**Consultation Response from KC,
Highways Development Management****2023/90792 Land Adjacent To, 6, Sands Terrace, Leeds Road, Huddersfield, HD2 1YX****Erection of two-storey workshop (Class E (g)) and associated works****Date Responded: 27-6-2023.****Responding Officer: Mark Berry****Responding Ref: 11-3NW-4**

This application seeks approval to the erection of a two-storey workshop (Class E (g)) and associated works at land adjacent to, 6, Sands Terrace, Leeds Road, Huddersfield.

SITE PLAN @ 1:200

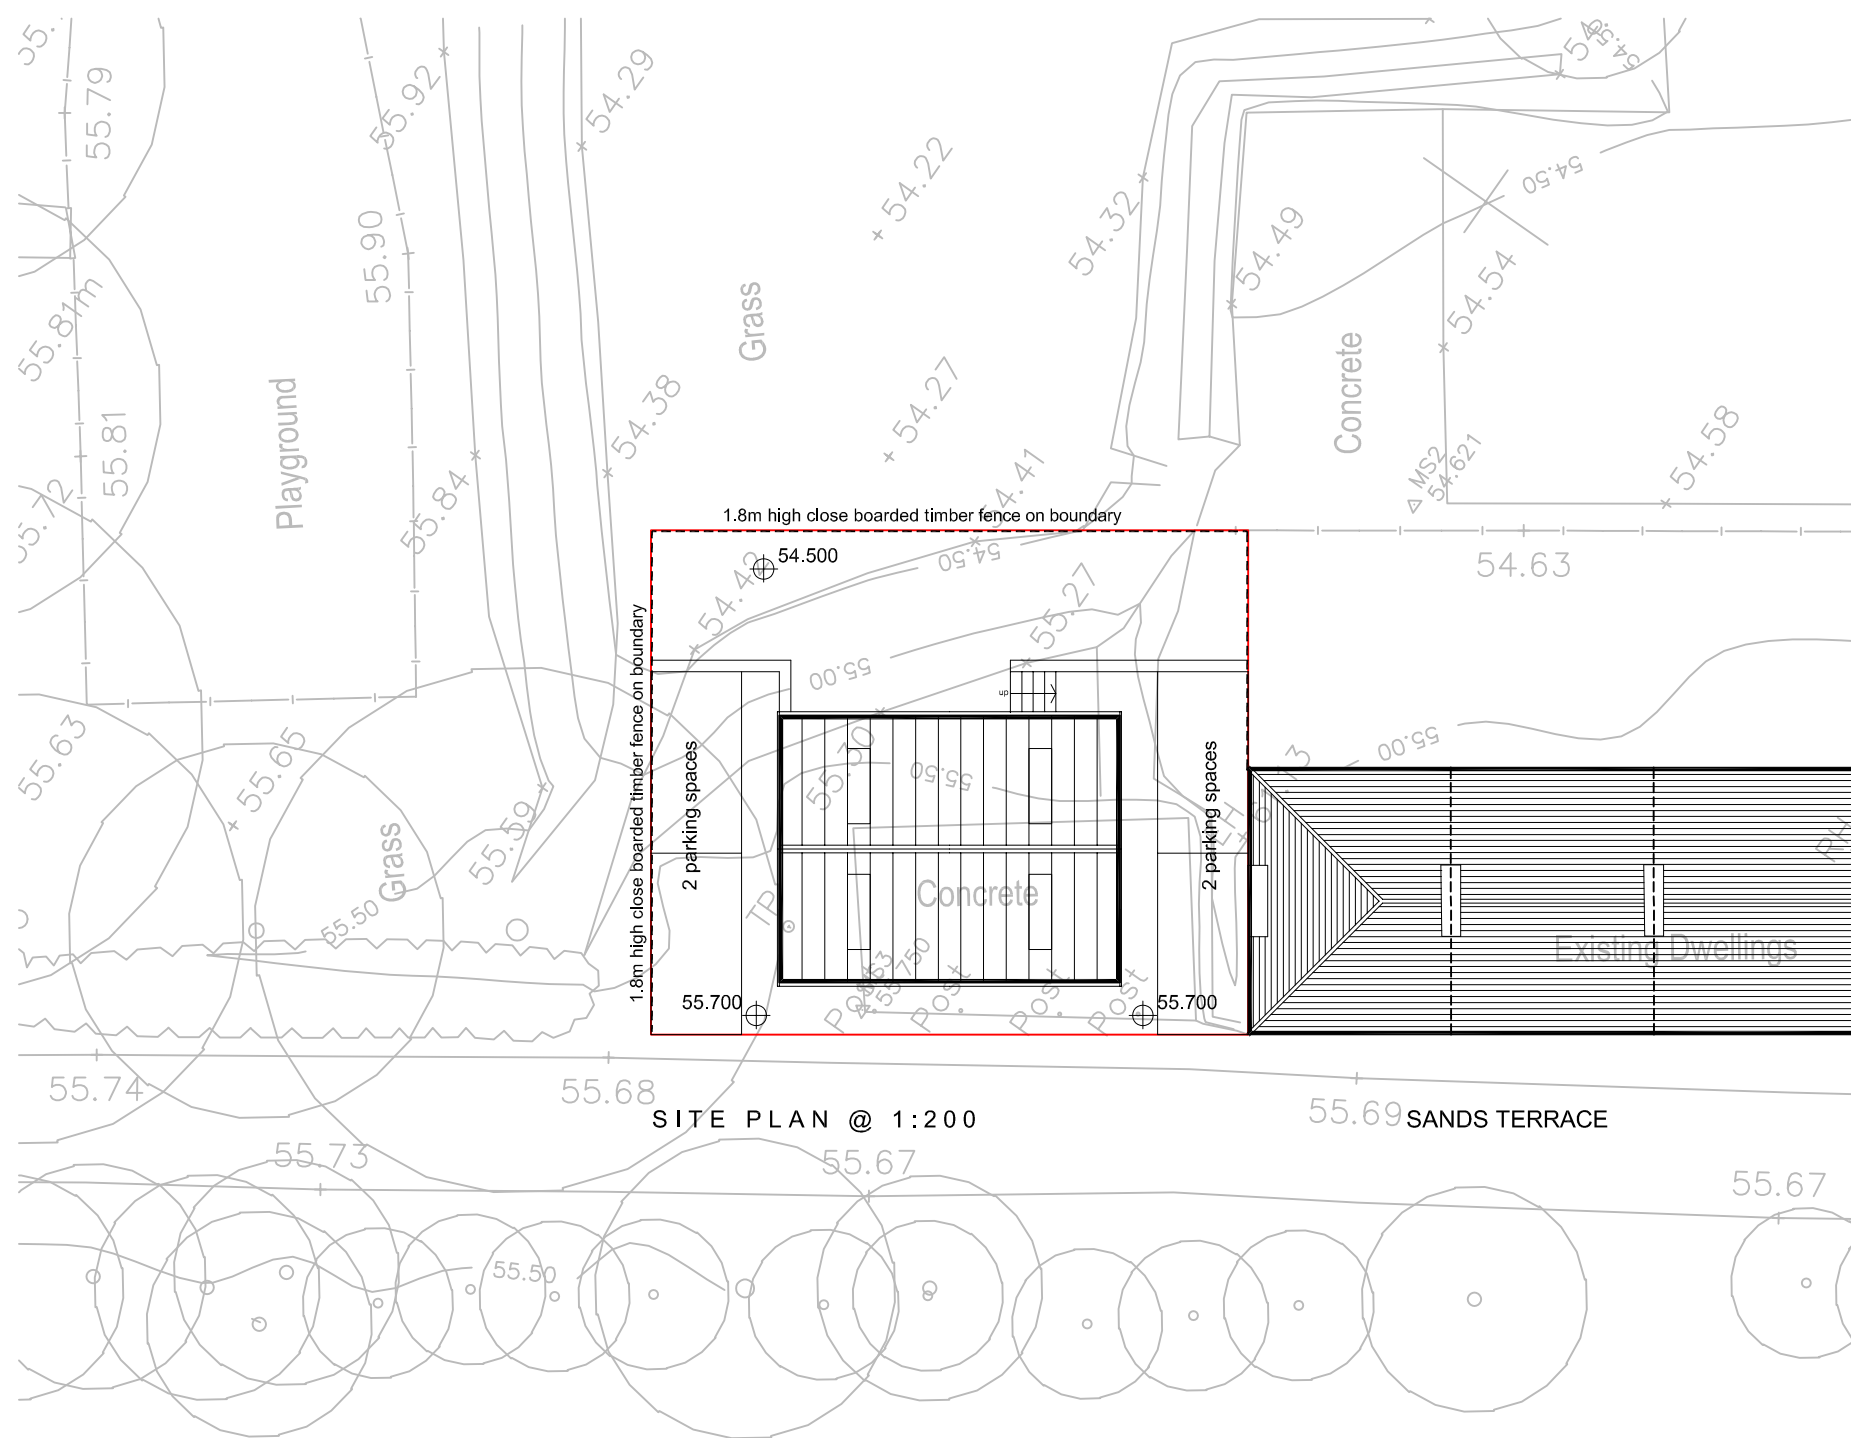
The proposals show a two-storey workshop with a gross floor area of just 79.5sqm with access directly onto Peace Pit Lane via roller shutter doors. Two off-street parking spaces are shown to either side of the proposed building.

There are however no proposals for servicing the proposed workshop. The applicants should demonstrate by means of swept paths that the largest vehicle anticipated to visit the site can enter, exit, and turn within the site.

Also, no details are provided regarding the applicant's proposals for the storage and collection of wastes from the site. A refuse vehicle should not have to reverse out of the site.
